HUDSON MINOR SUBDIVISION Construction Drawings El Paso County, Colorado

TITLE SHEET

| NO. | REVISION | BY | DATE |
|-----|------------------|-----|--------|
| 1 | COUNTY SUBMITTAL | JPS | 3/8/18 |

G1

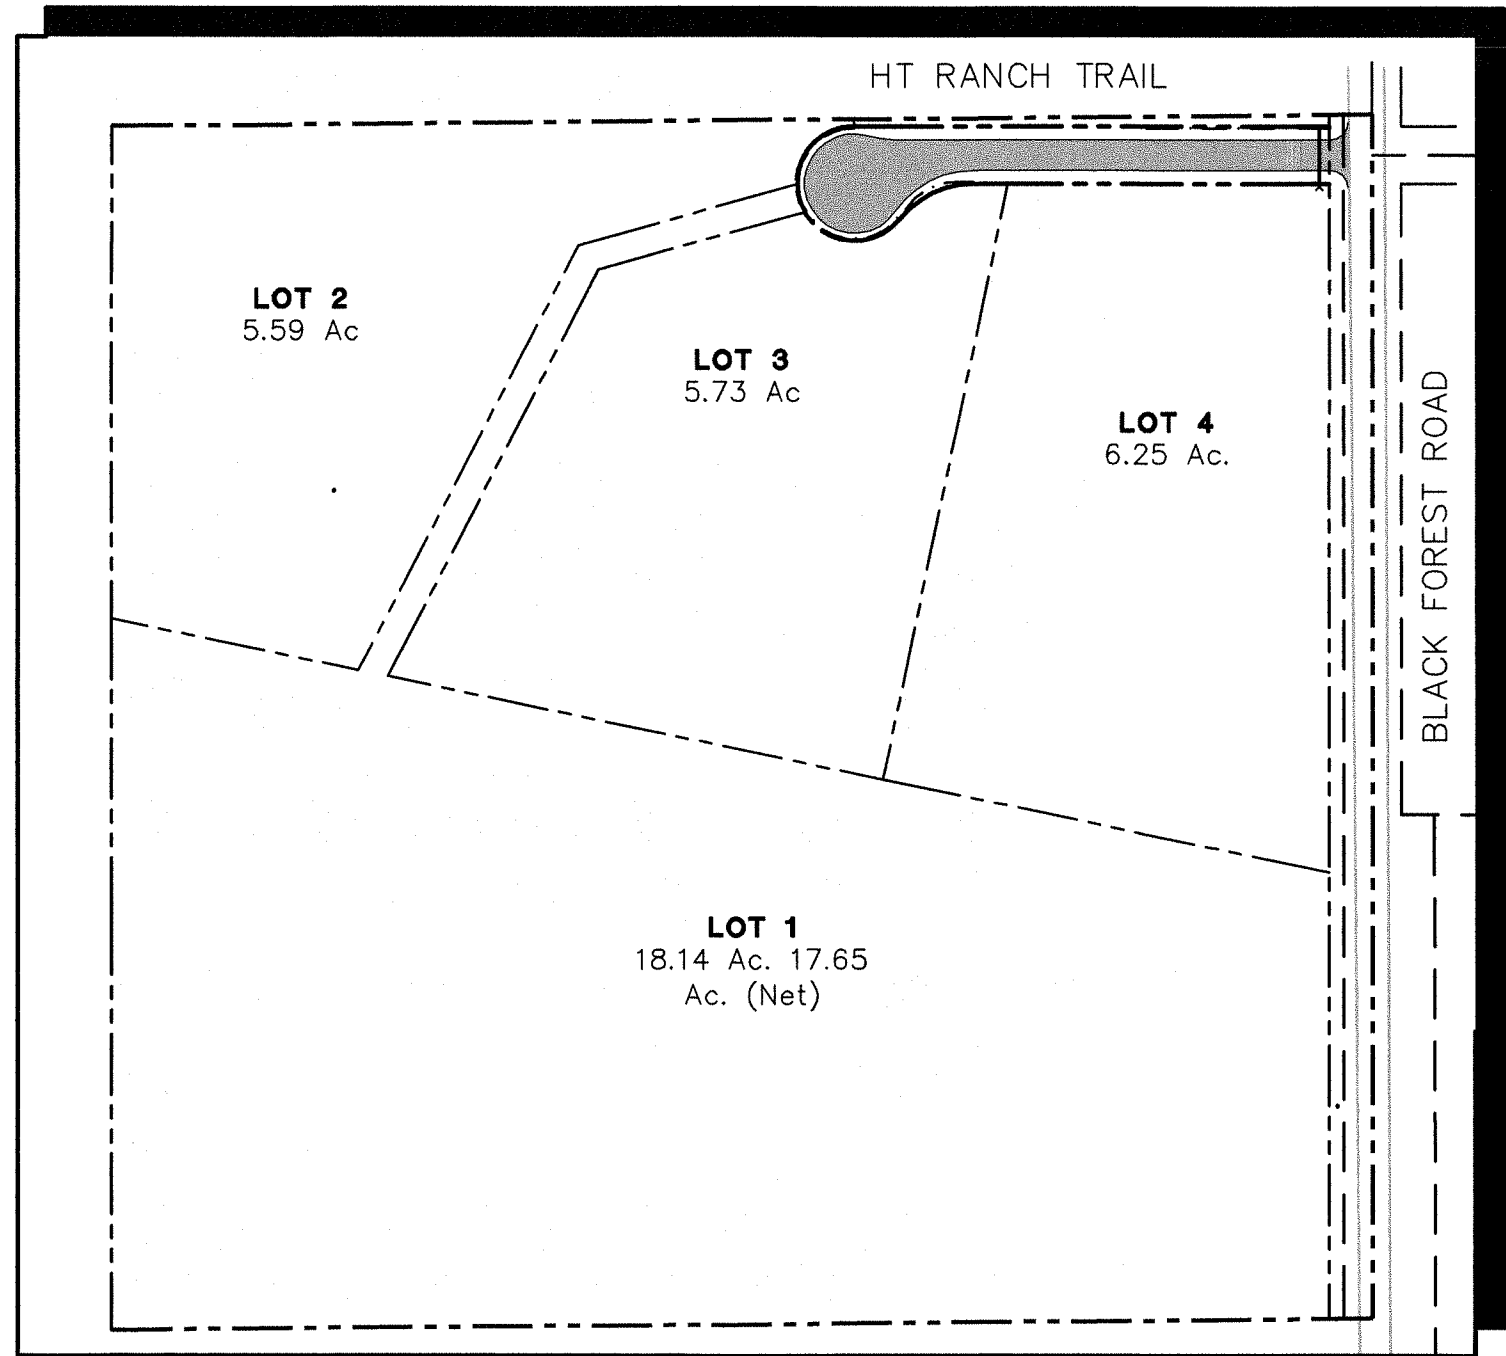
Add as a 3rd paragraph:
In accordance with ECM Section 1.12, these construction documents will be valid for construction for a period of 2 years from the date signed by the El Paso County Engineer. If construction has not started within those 2 years, the plans will need to be resubmitted for approval, including payment of review fees at the Planning and Community Development Directors discretion.
